DRB Application No.: 04DRB-00247 (SBP)

Project # 1003100

Project Name: Adobe Wells Subdivision

TO: Sheran Matson, Chair, Development Review Board
FROM: Deborah L. Stover, Senior Planner, Development Services
DATE: 3-2-04
SUBJECT: EPC CONDITIONS FOR PROJECT 1003100

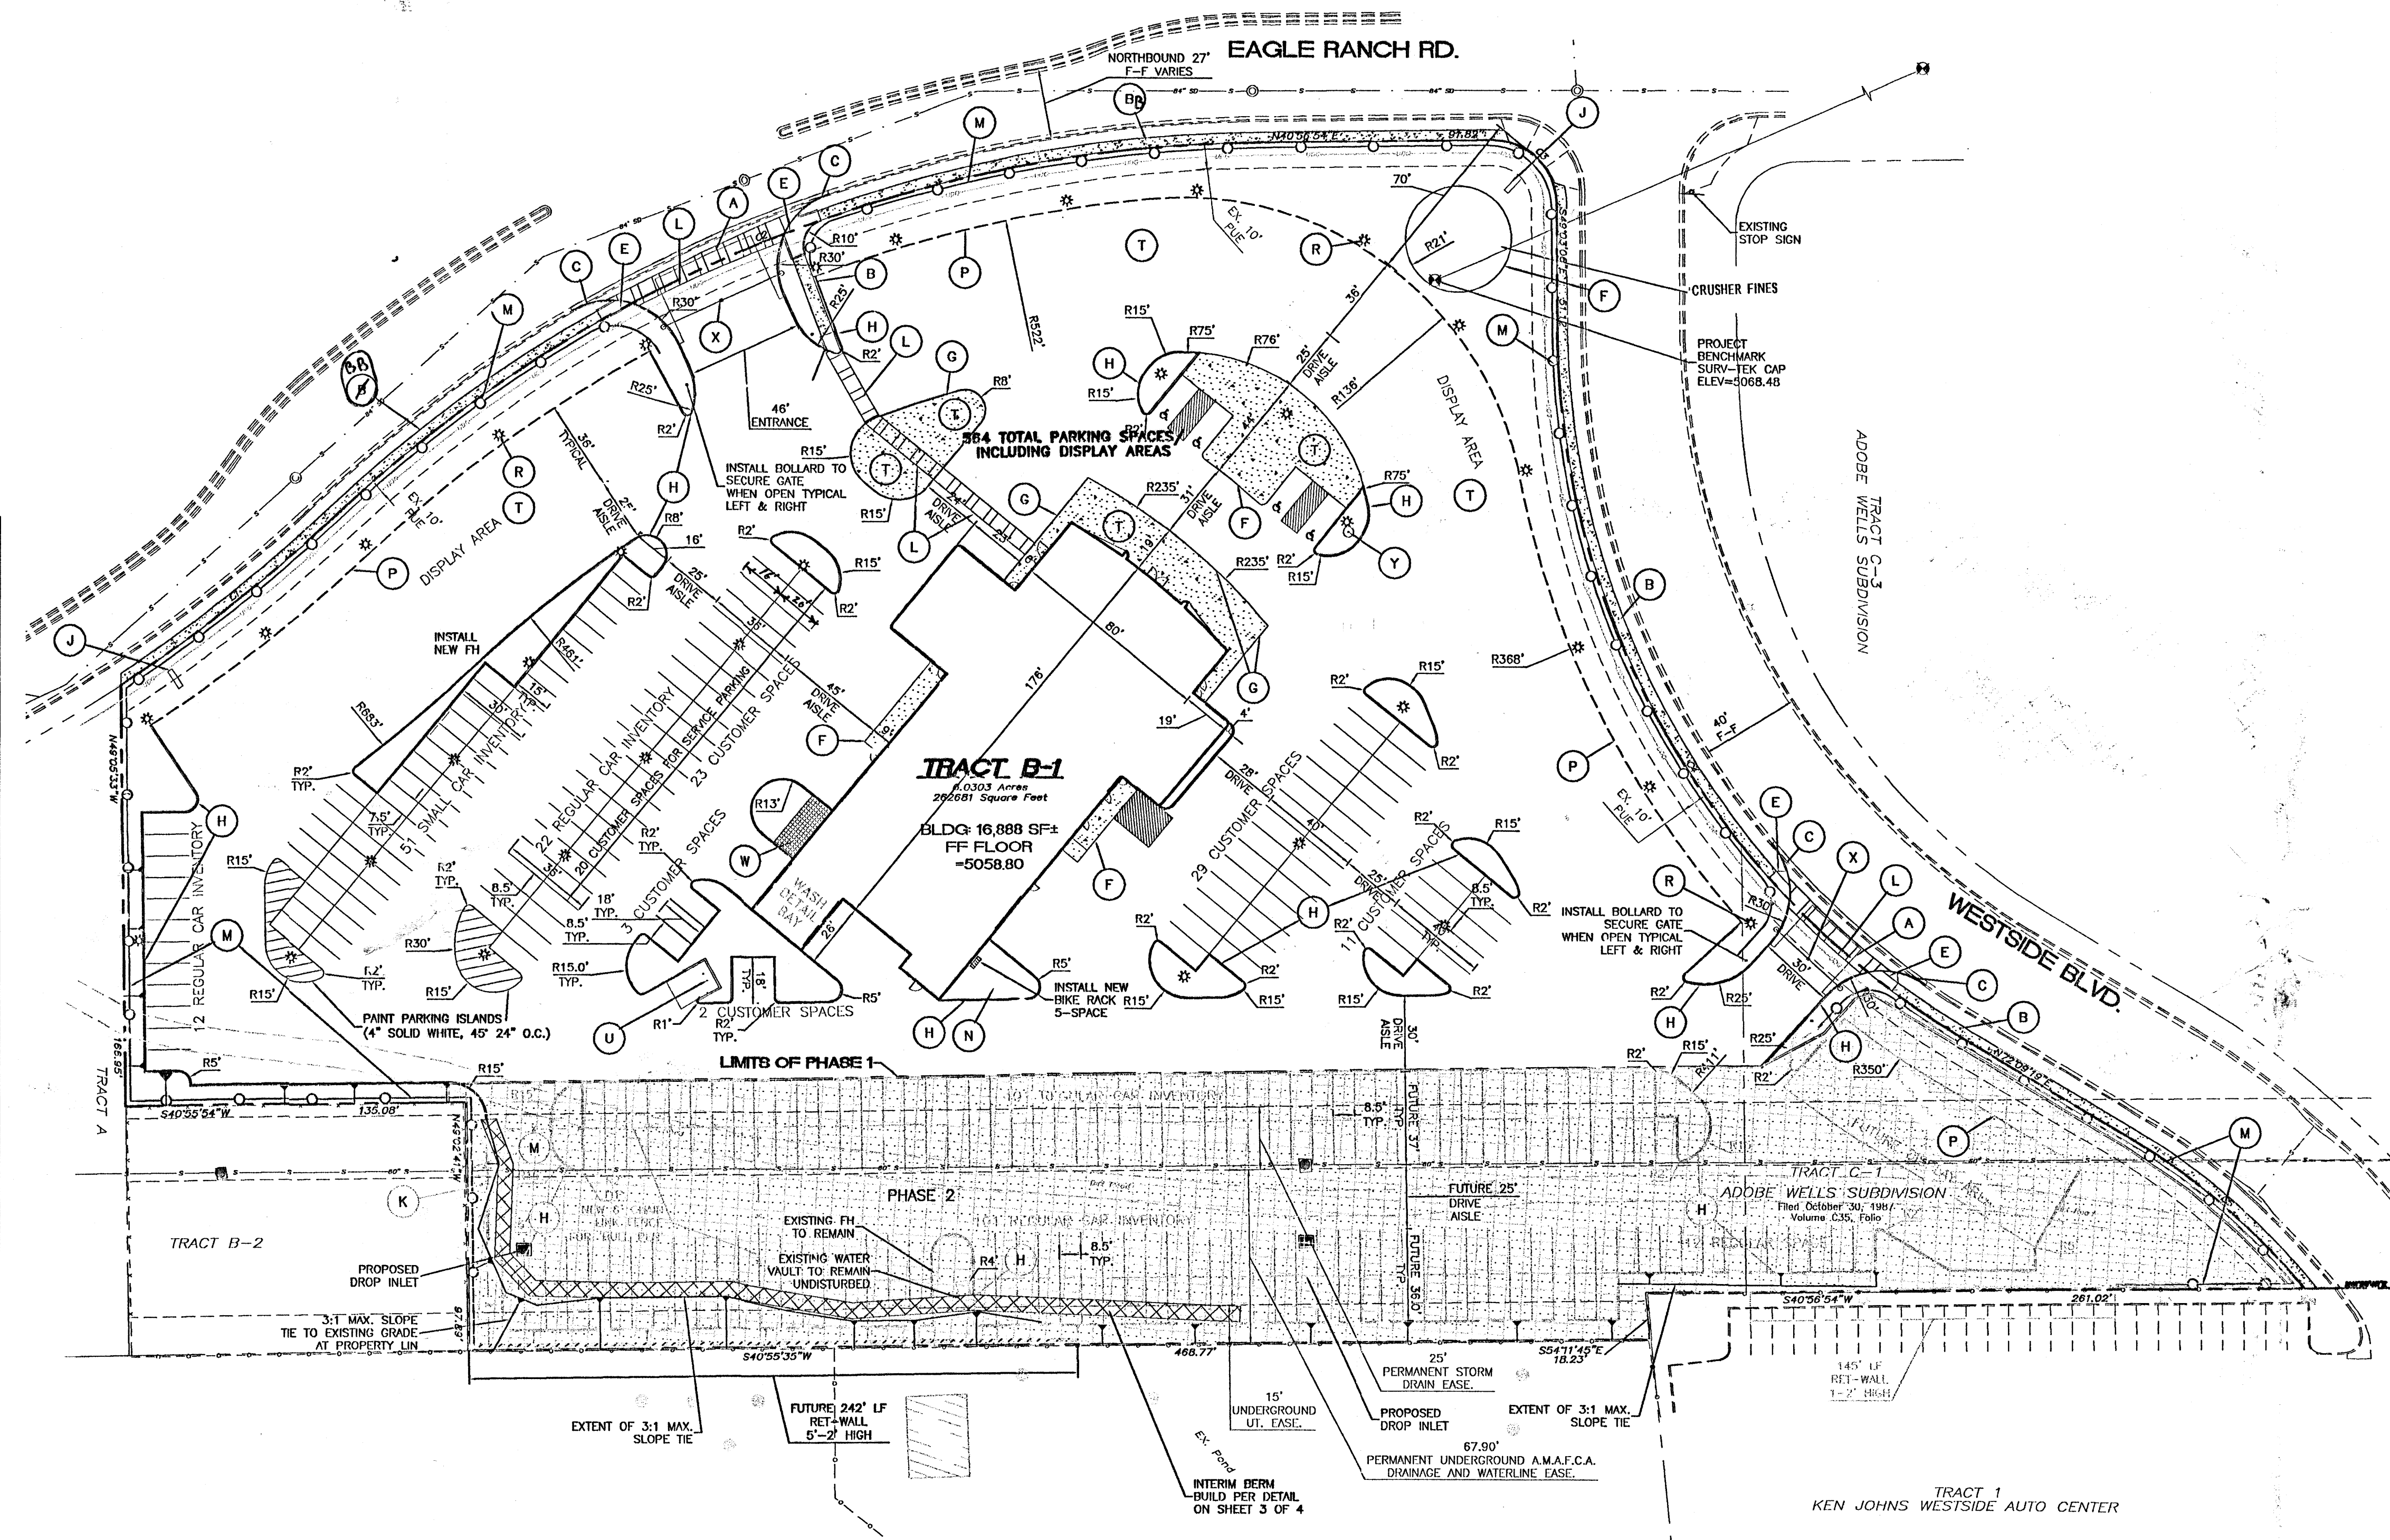
Condition #3: No outdoor loudspeakers or other amplified public address systems shall be permitted.

→ *This statement shall be noted on the site plan.*

ENGINEER'S SEAL	<b>KIA WESTSIDE AUTO DEALERSHIP</b>	DRAWN BY JC
		DATE 01-27-2004
	<b>LANDSCAPE PLAN</b>	2396CRB-012704X.DWG
	<b>TERRA WEST, LLC</b> 8509 JEFFERSON NE ALBUQUERQUE, NEW MEXICO 87113 (505) 858-5100	SHEET # <b>2 OF 5</b>
RONALD R. BOLIANNAN P.E. #7868		JOB # 230096

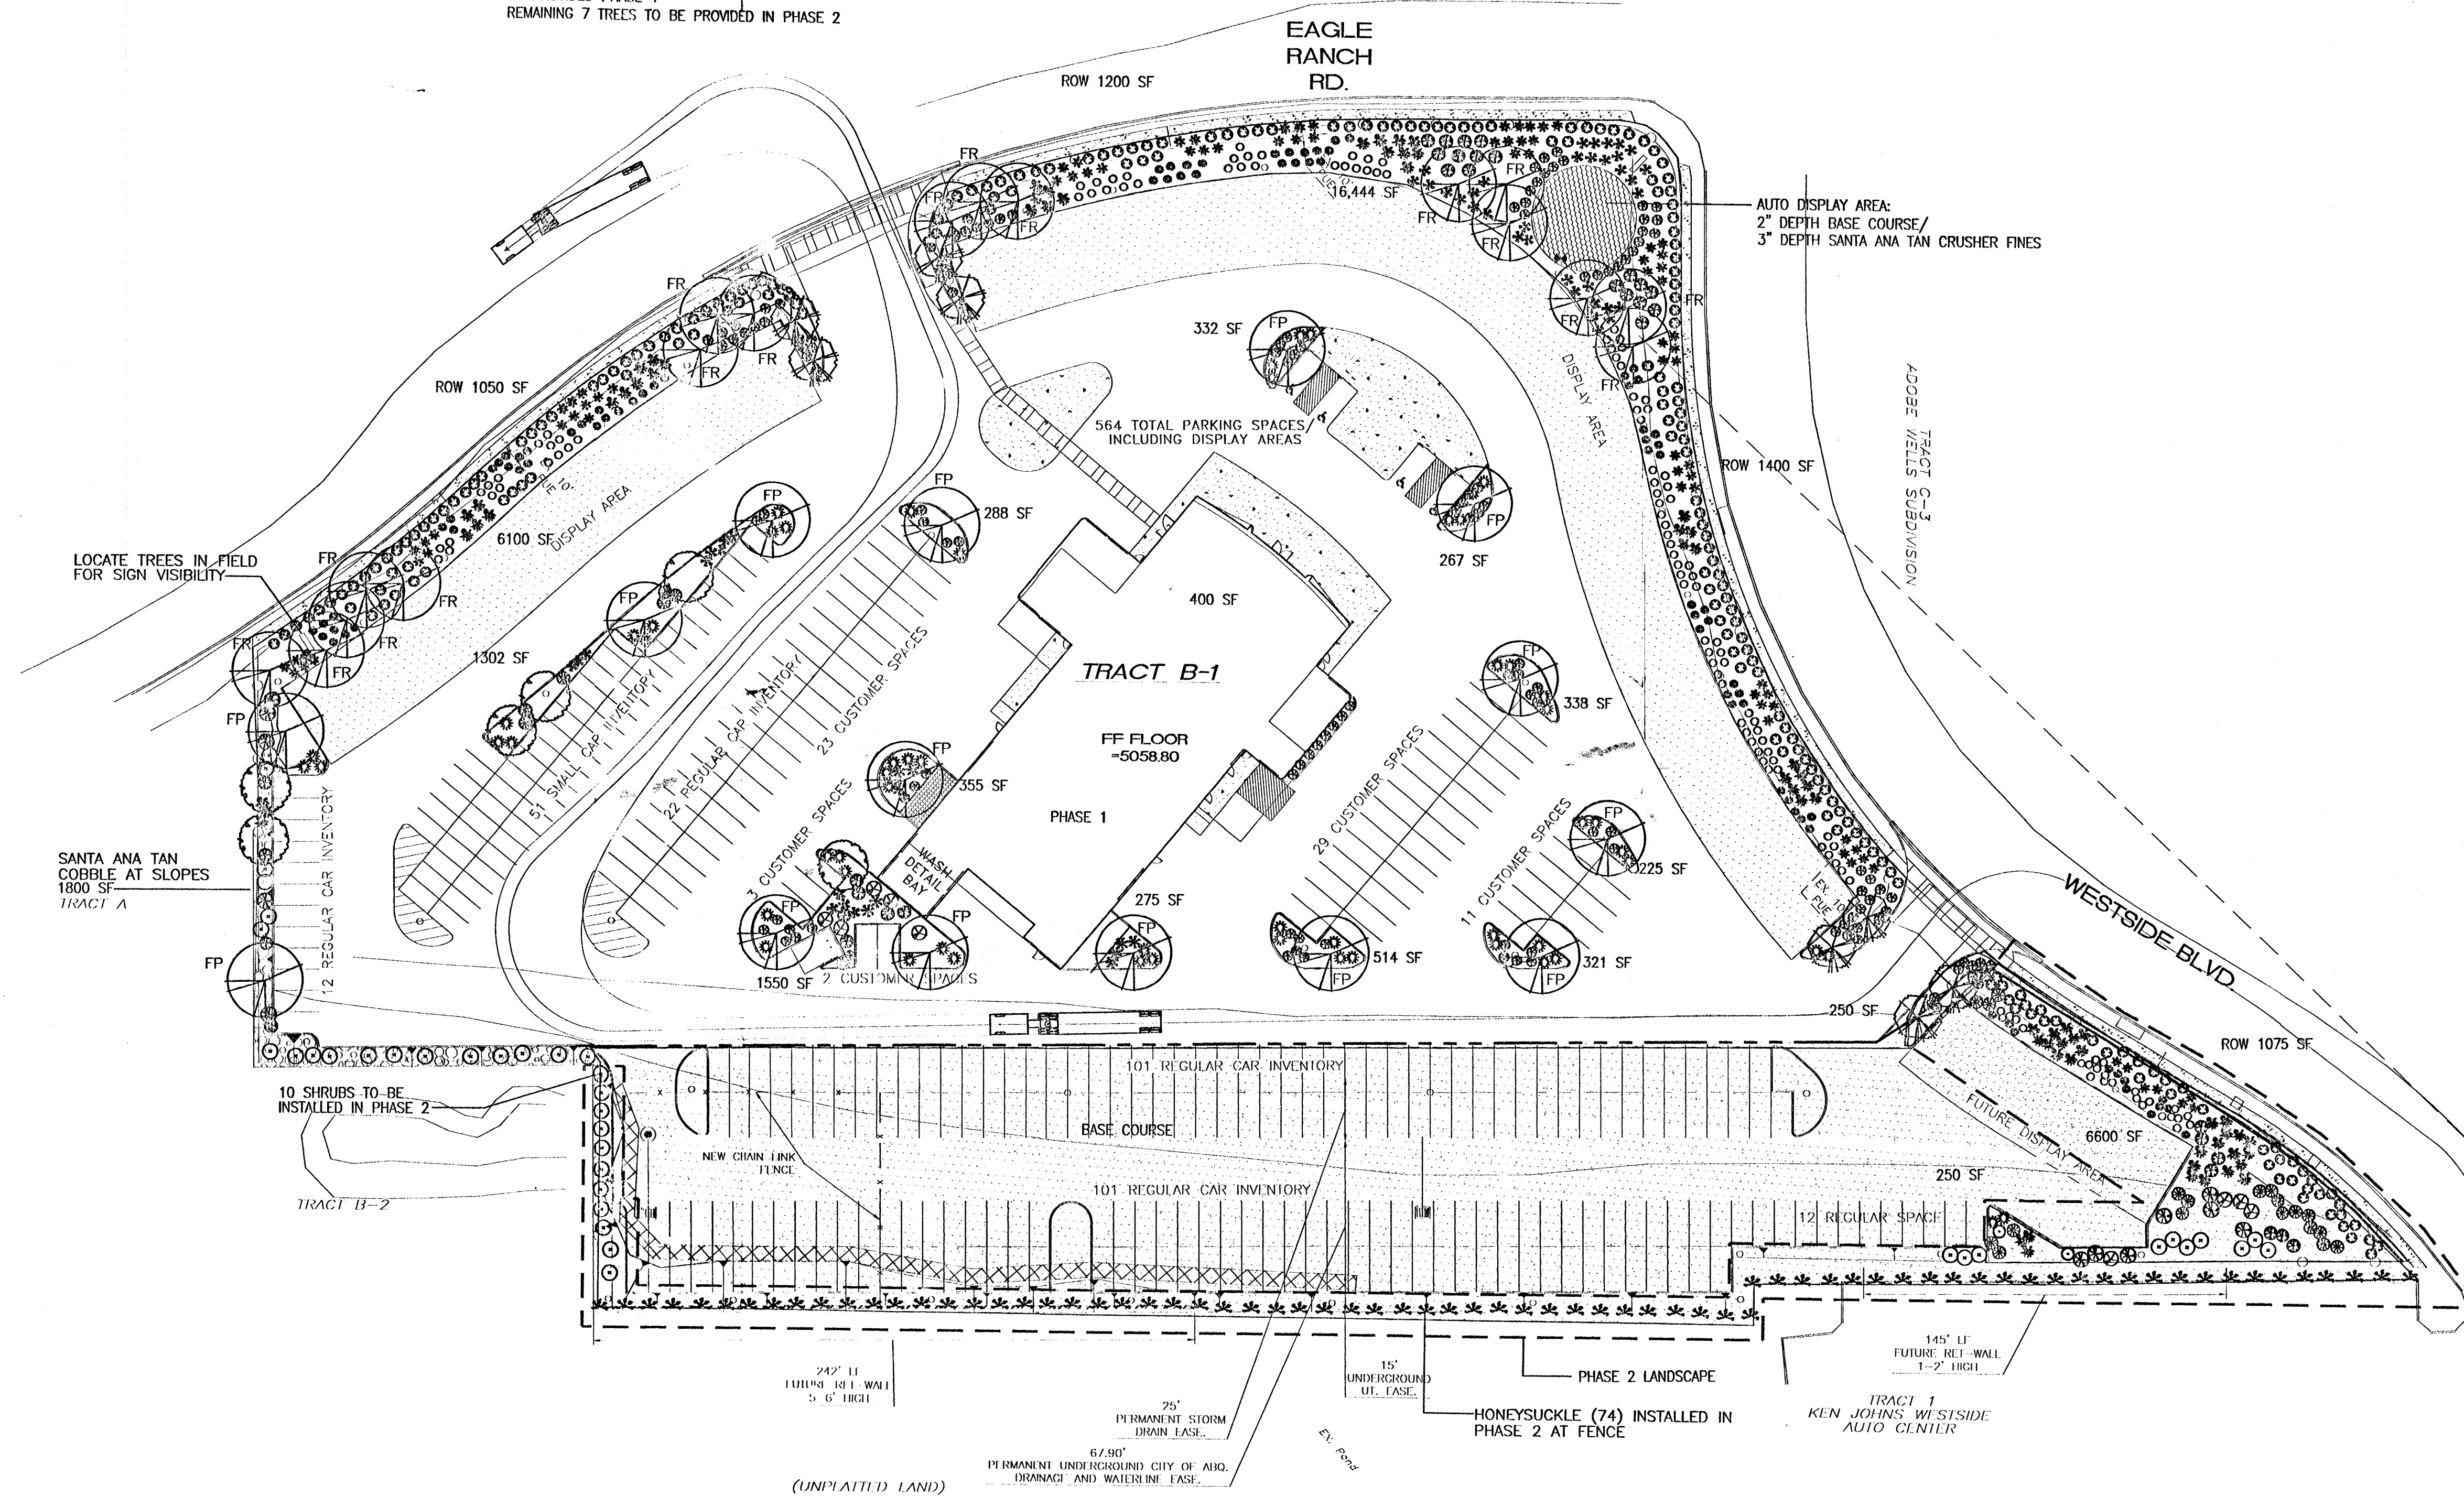
Condition #5: a) Vines shall be planted along the chain link fence area to mitigate the visual effects of this fence.

→ *The applicant states that this will be done in Phase II. This area shall be labeled, as Phase II and the vines shall be shown on the landscape plan as part of the Phase II development.*
